### Application No. LUPL-25-0008

**Record Type : Land Use Plan**

### Document: 241010\_BLR Village C Land Use Plan.pdf

**ISSUE RECORD**

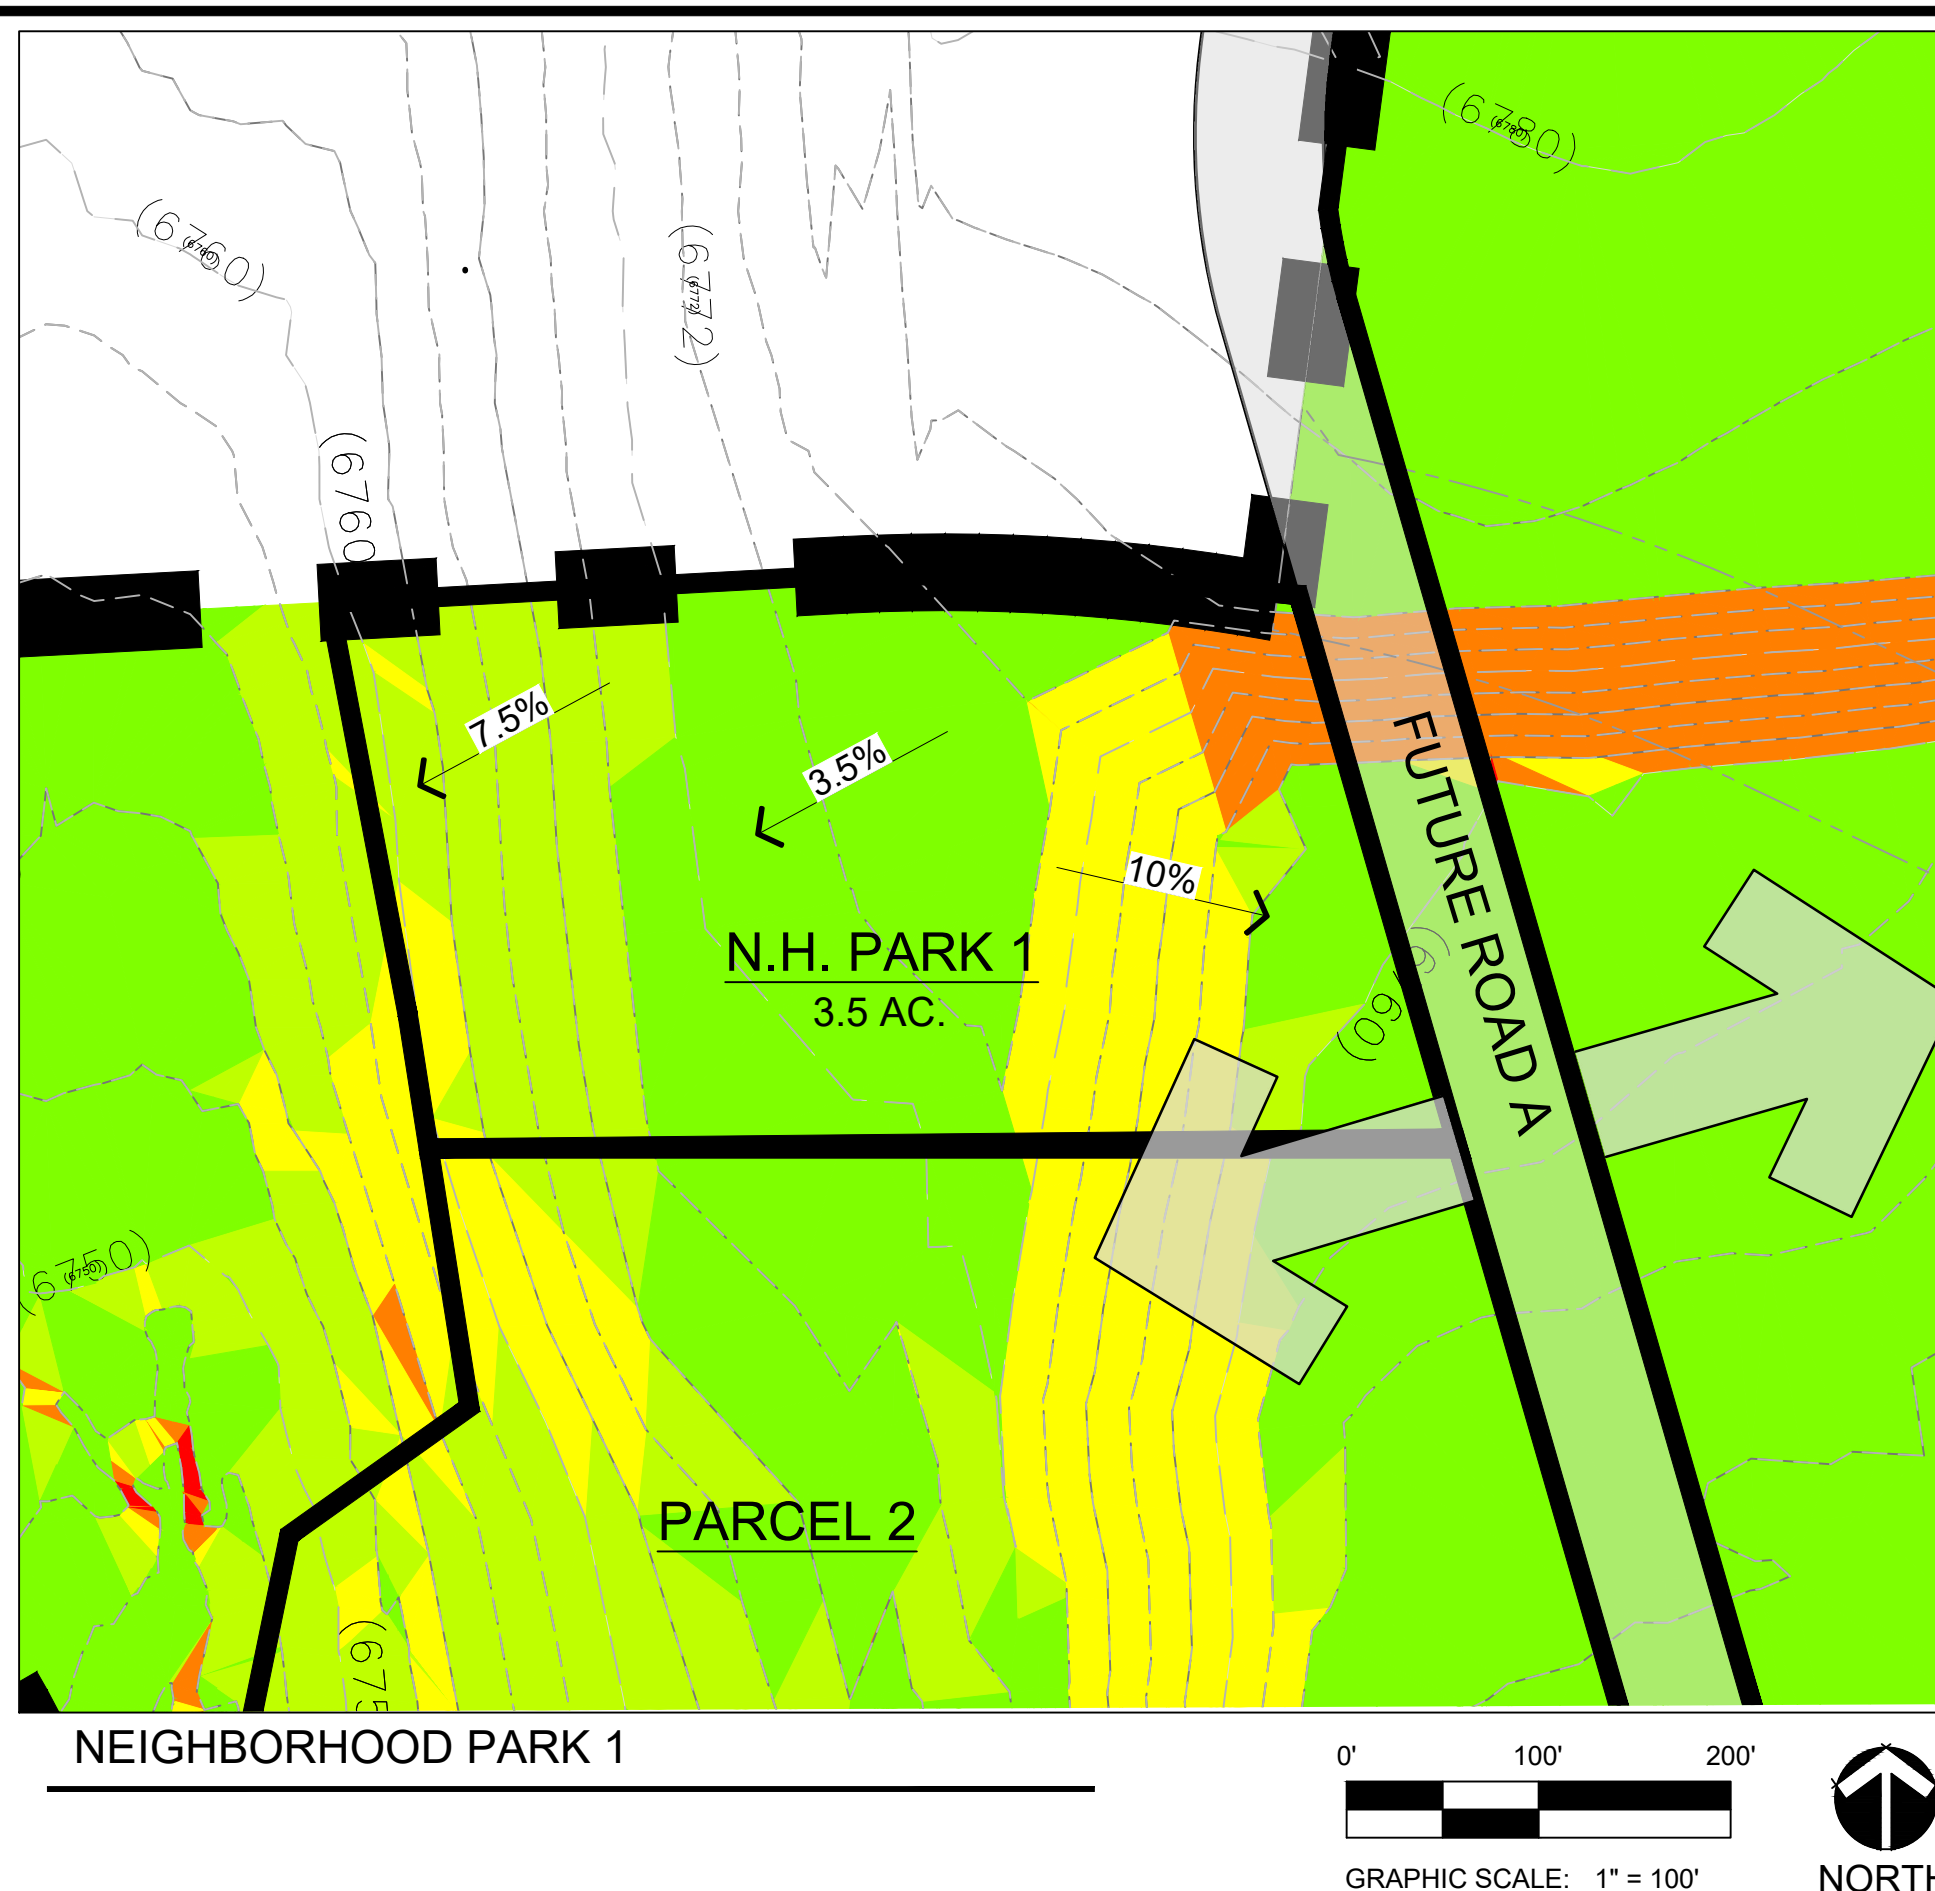
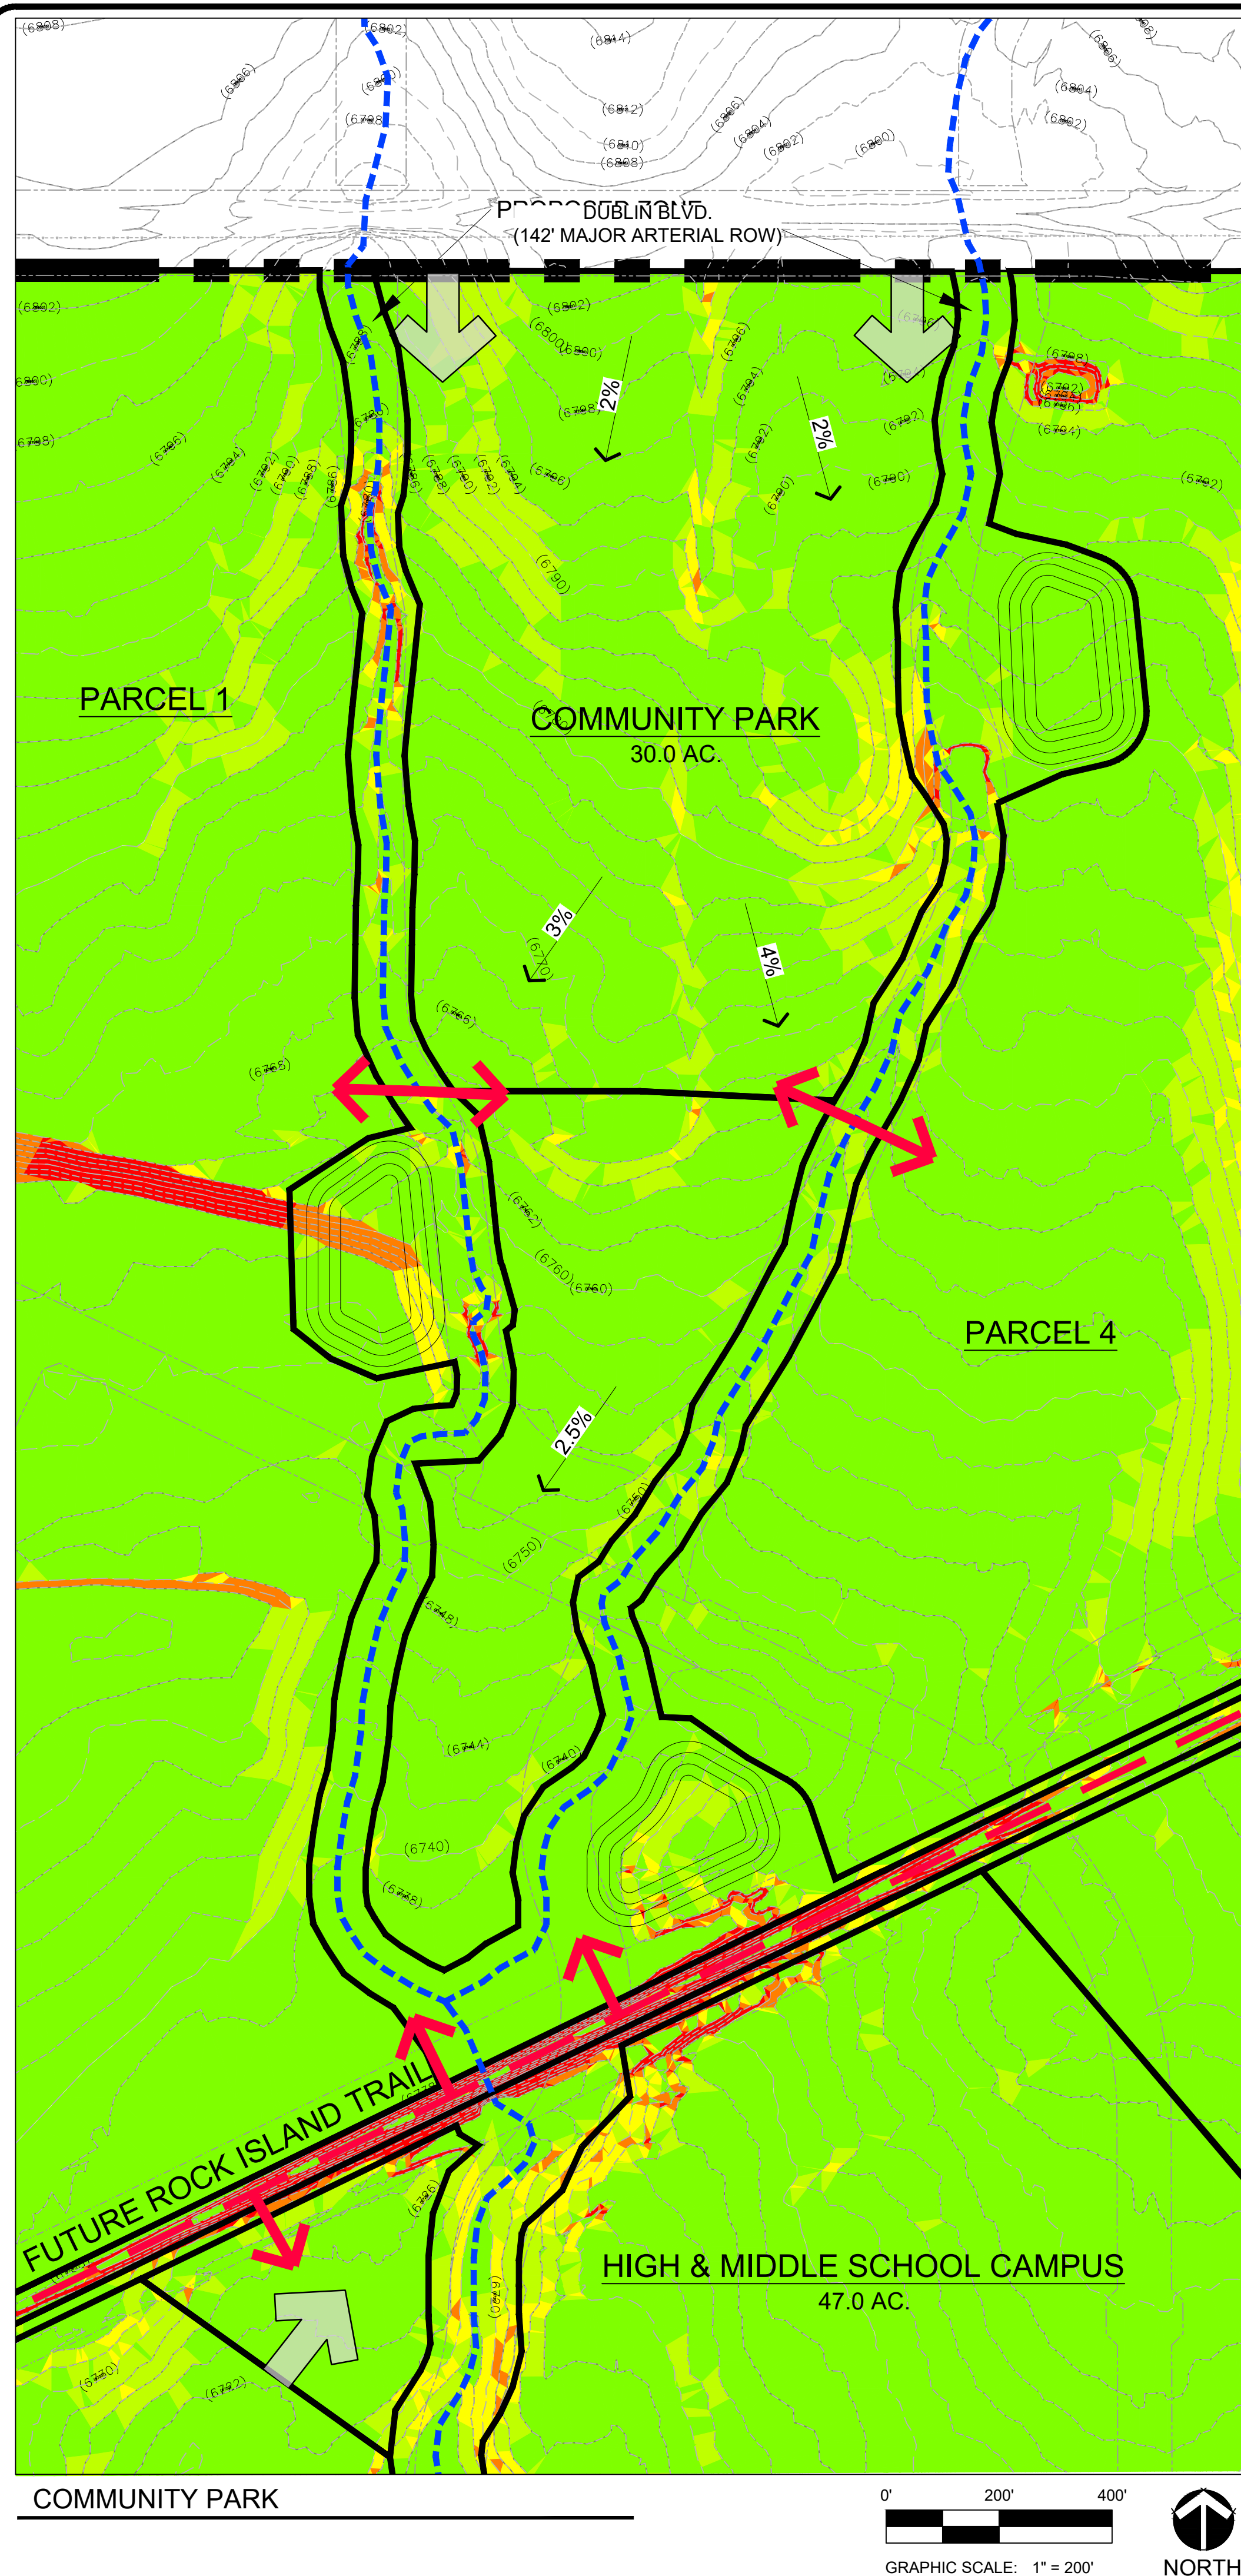
Comment ID	Page Reference	Annotation Type	Reviewer : Department	Status	Review Comments	Applicant Response Comments
82	1	Callout	Tamara Baxter : Planning	Open	verify that all the acreage match those on sheet 2	<b>Guest</b> - 11-04-2025 14:53:54  Verified and matching

Comment ID	Page Reference	Annotation Type	Reviewer : Department	Status	Review Comments	Applicant Response Comments
88	2	Callout	Tamara Baxter : Planning	Open	Will future residential in this area be limited to the 3-156 du/ac, similar to R-Flex Med?	<p>Guest - 11-05-2025 10:11:24</p> <p>Density for the MX-M has not been determined yet and is still being reviewed.</p>

25	2	Note	District #49 : School Districts	Open	PK-8 proposed	<p>Guest - 09-10-2025 09:32:21</p> <p>Updated</p>
